WAYNFLETE LOWER SCHOOL - ADDENDUM #1

date: Monday, January 30, 2017
project: Waynflete Lower School Addition & Renovations, 2013-0050
prepared by: Austin Smith Scott Simons Architects
to: Cordelia Pitman Wright Ryan Construction
Rick Bergeron Wright Ryan Construction
Luke Dione Wright Ryan Construction
Anne Hagstrom Waynflete School
Patrick Boure Waynflete School
Phil LaClaire PML Project Management

Subject: Addendum #1 to Bid Documents of January 12, 2017

A411R

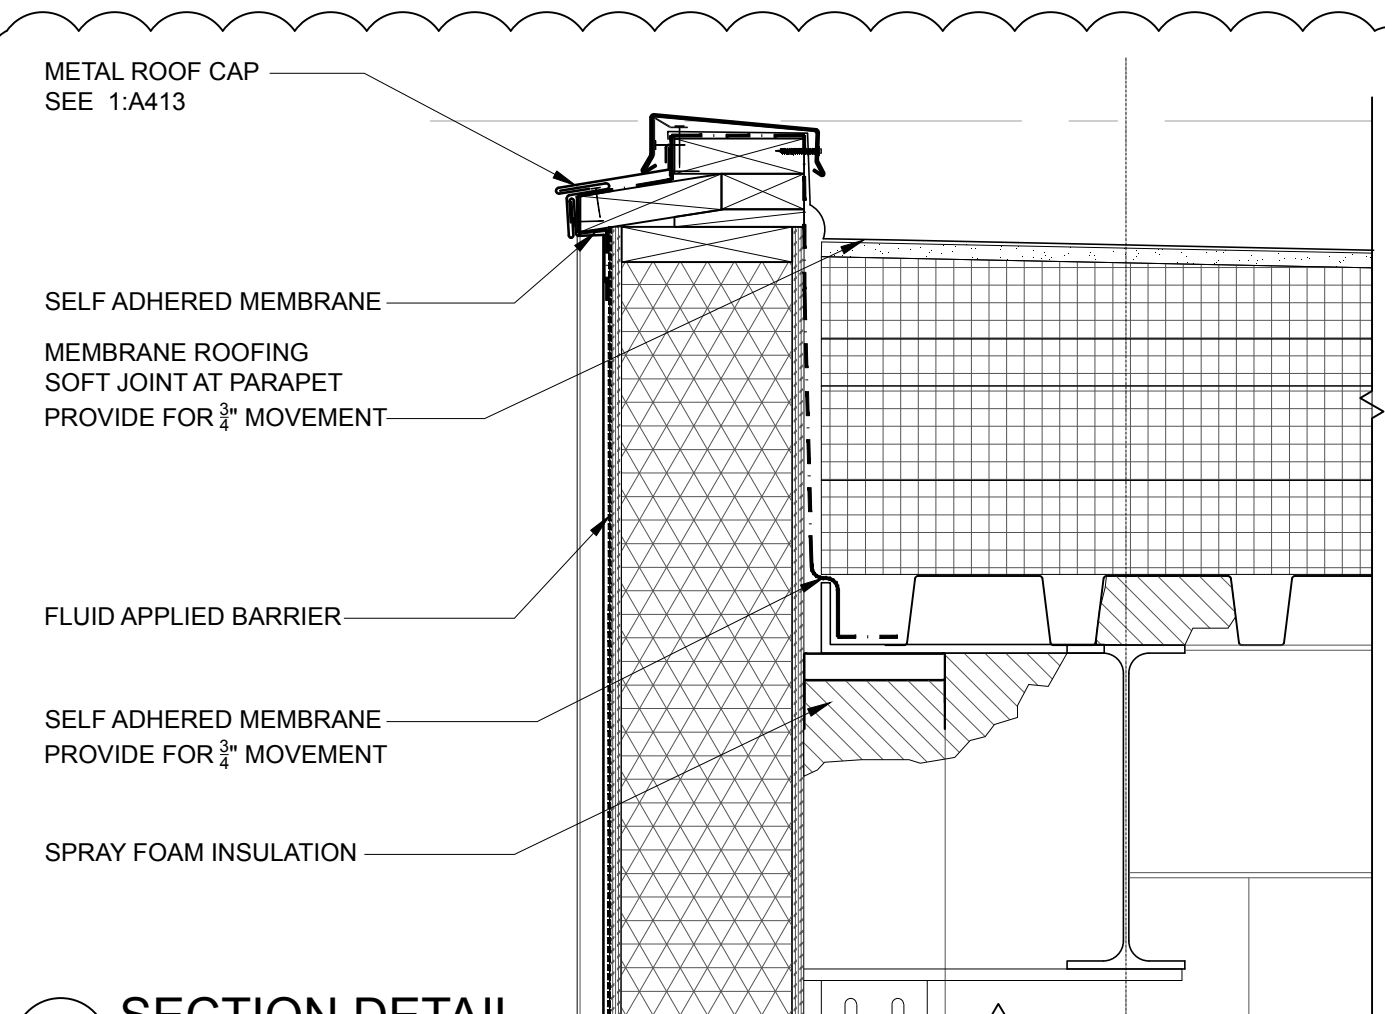
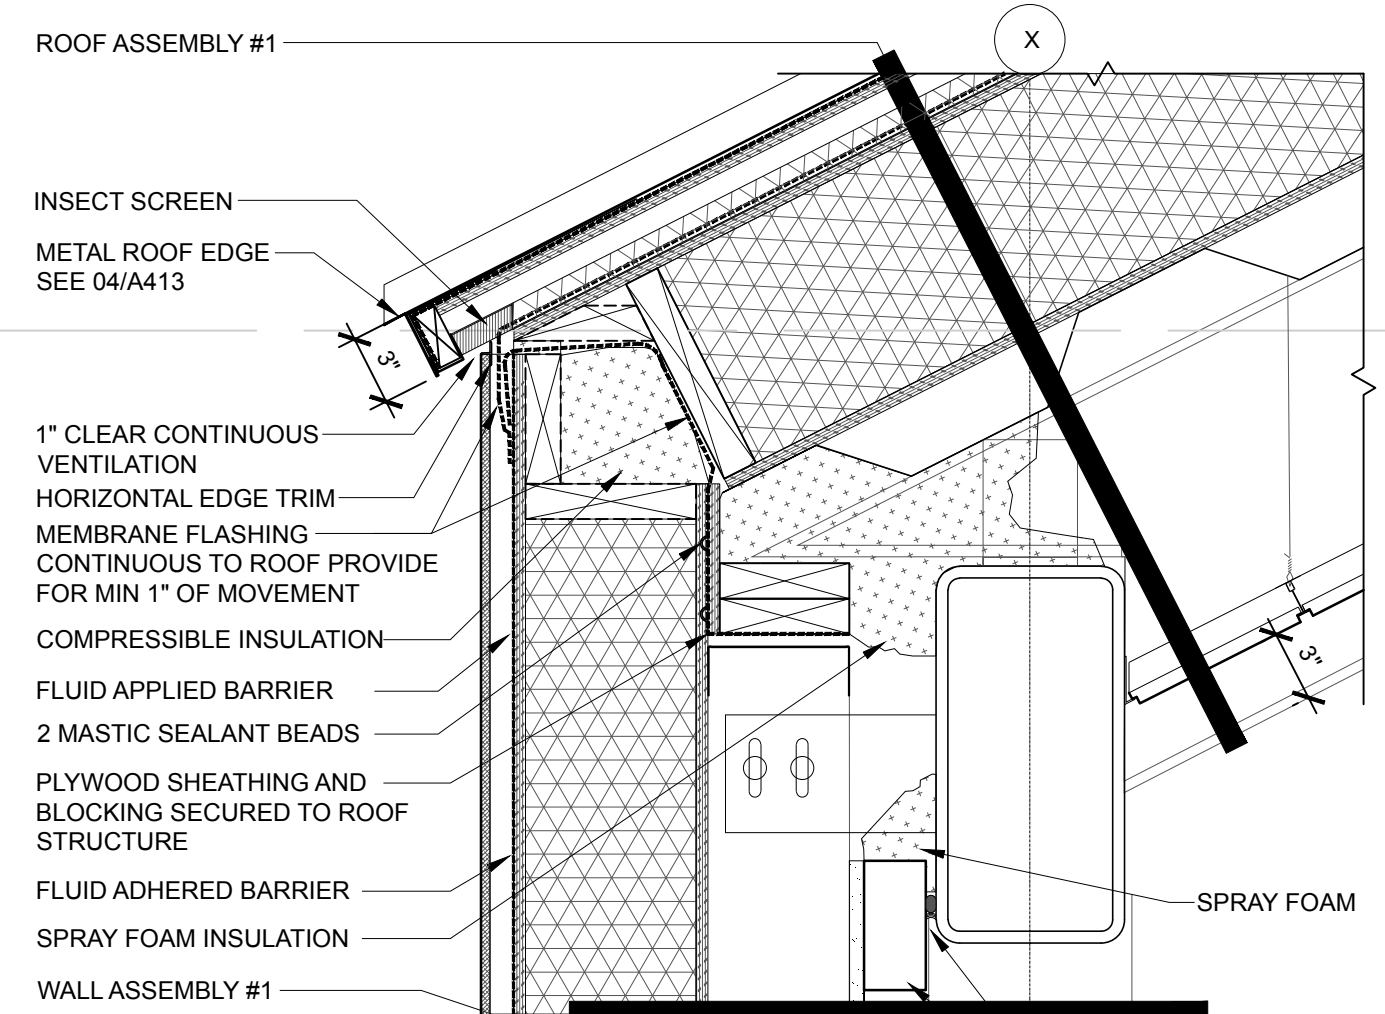
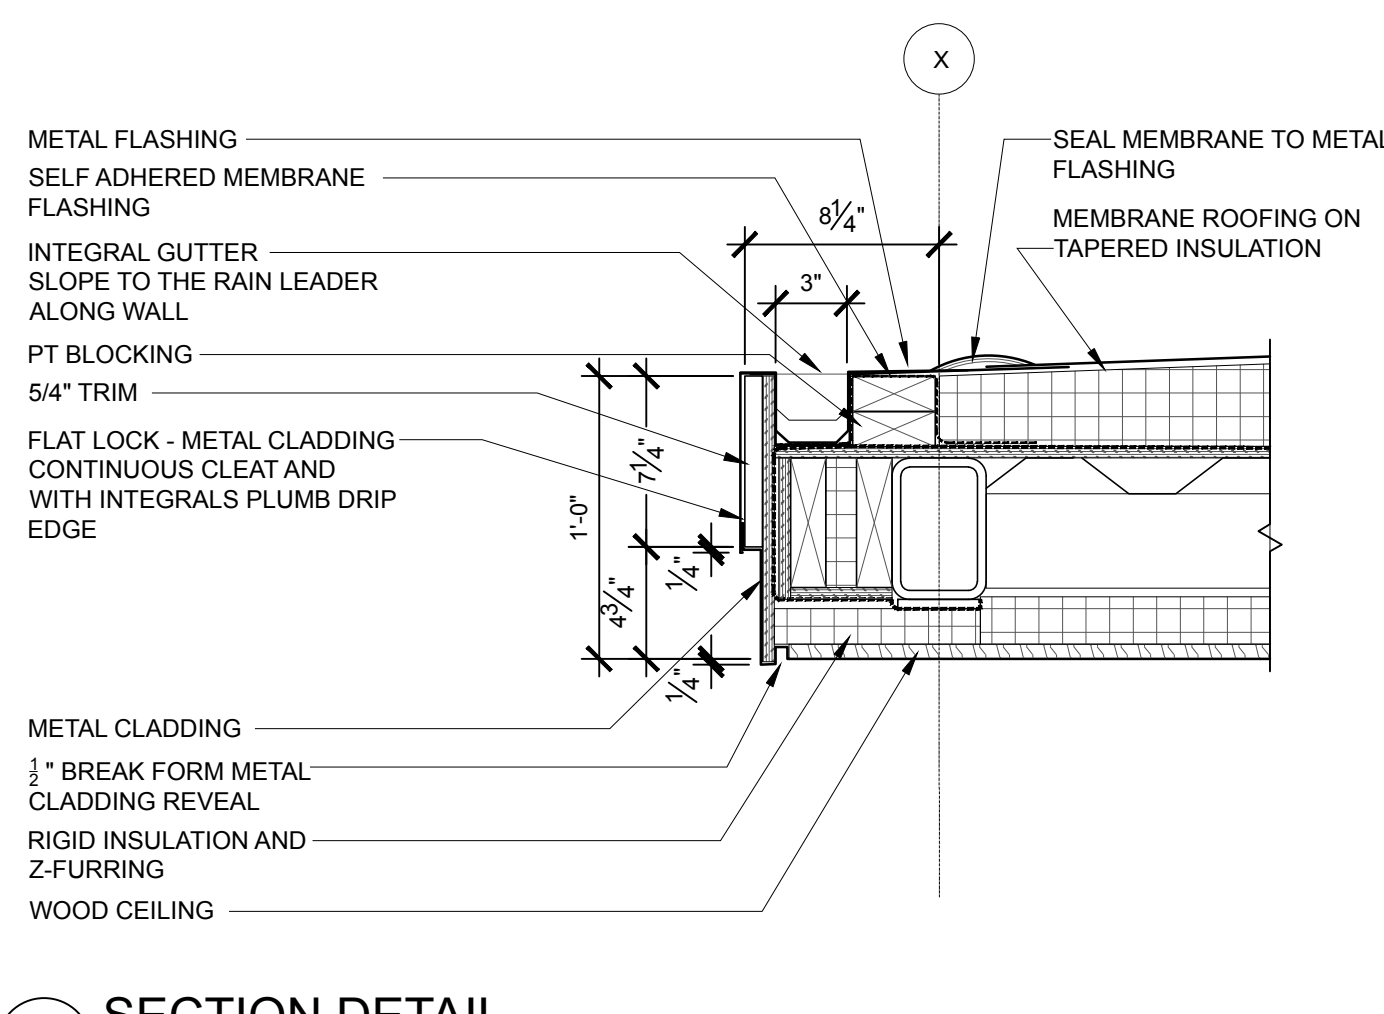
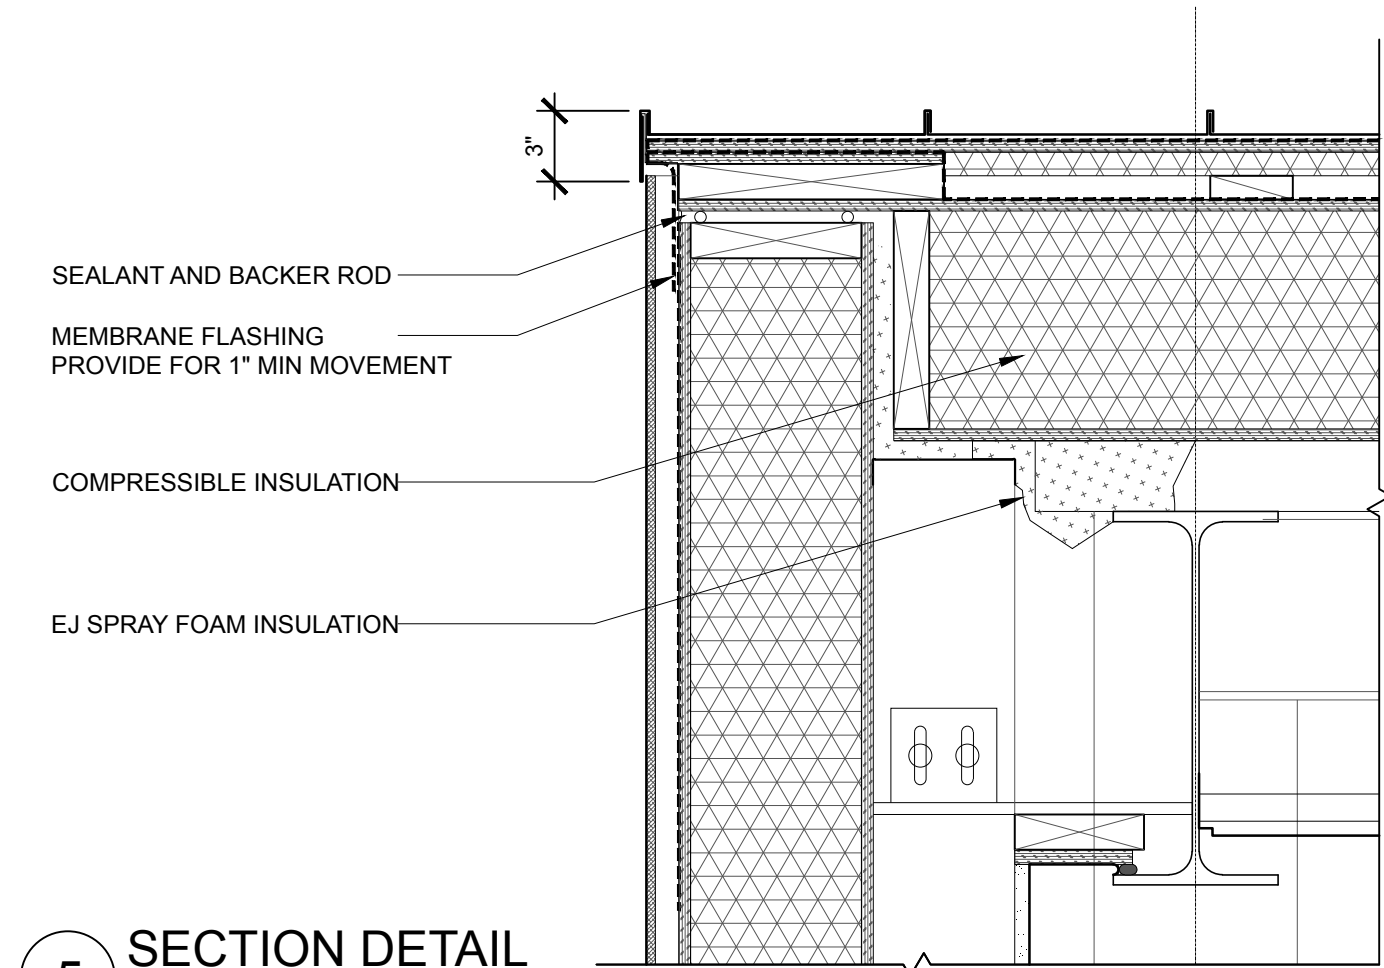
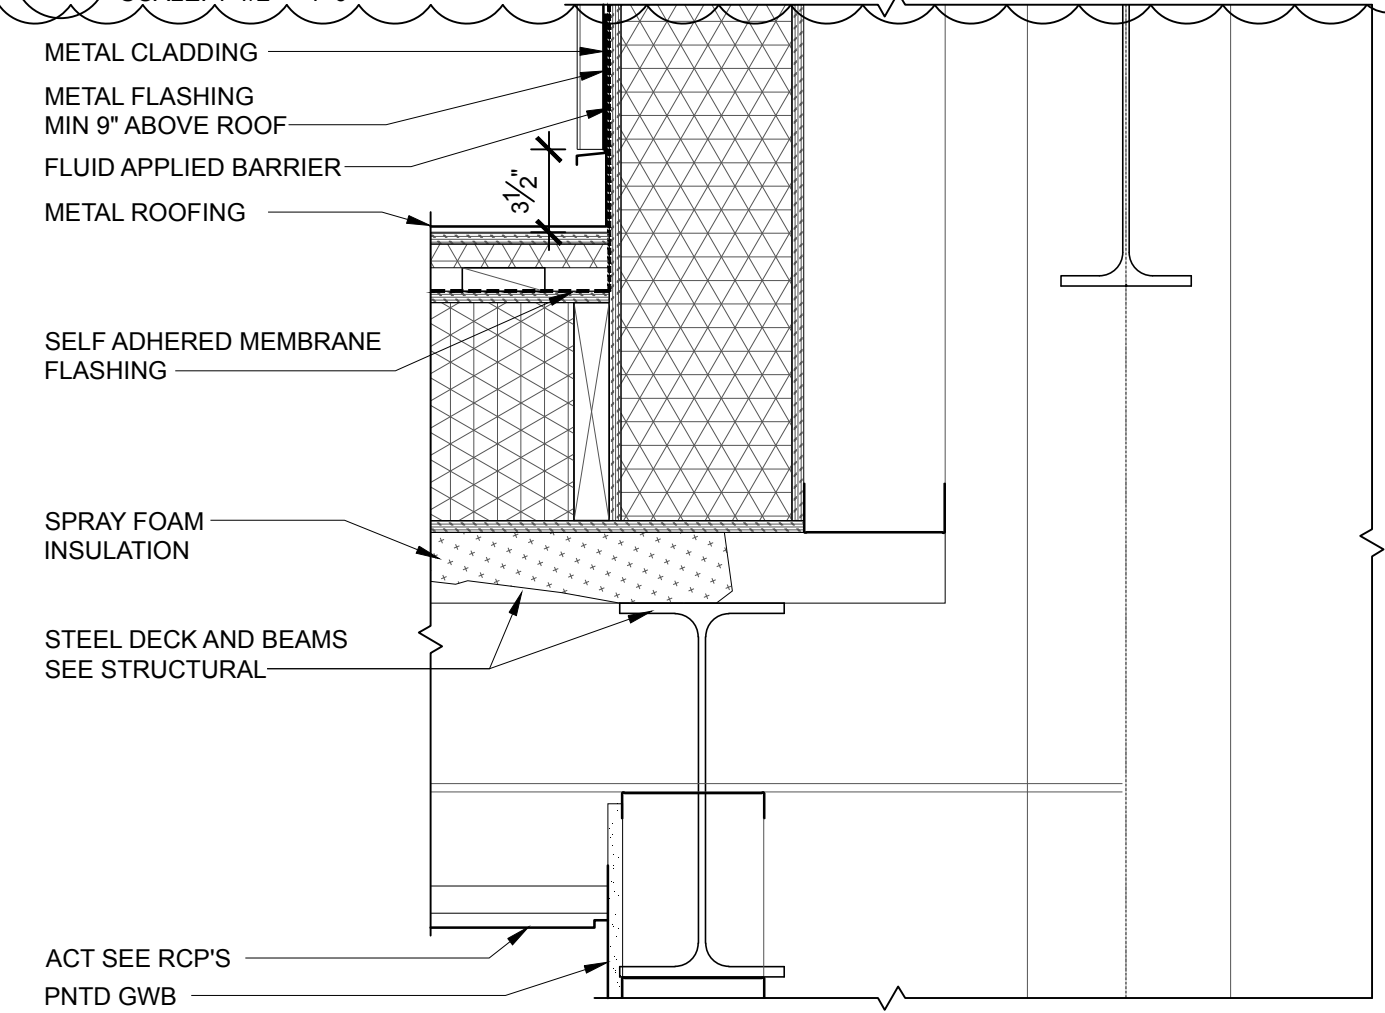
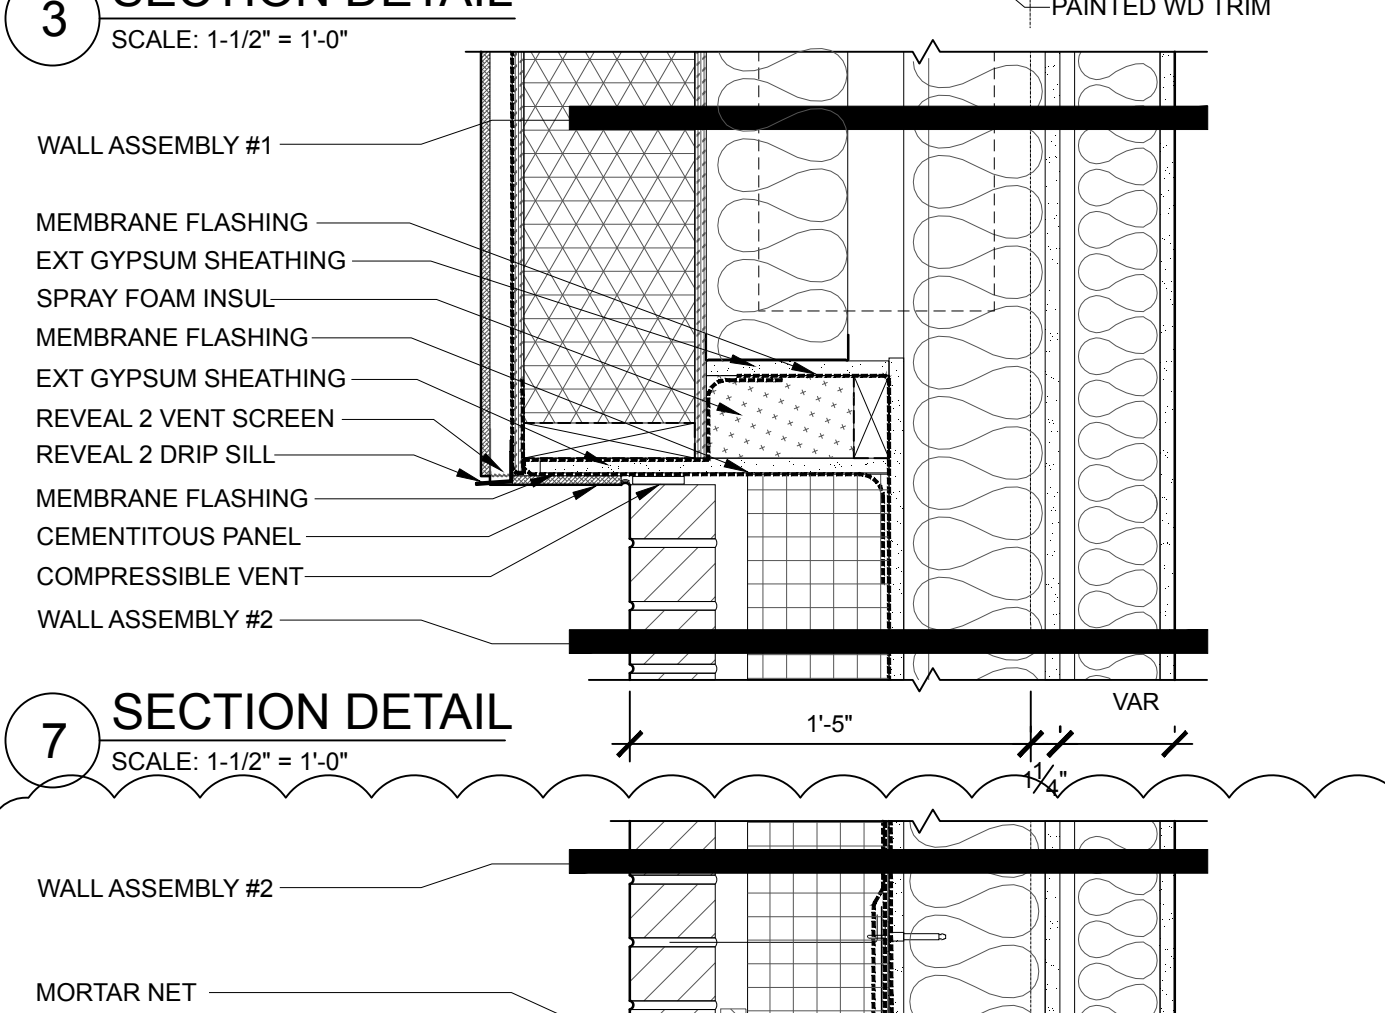
- 1-D17 Sheet A411 Replace drawing sheet with revised sheet **A411R**.
- 1-D18 Sheet A412 Replace drawing sheet with revised sheet **A412R**.
- 1-D19 Sheet A502 At Detail 1 title:
Delete: “STAIR S41 PLAN”
Add: ““STAIR S21 PLAN”
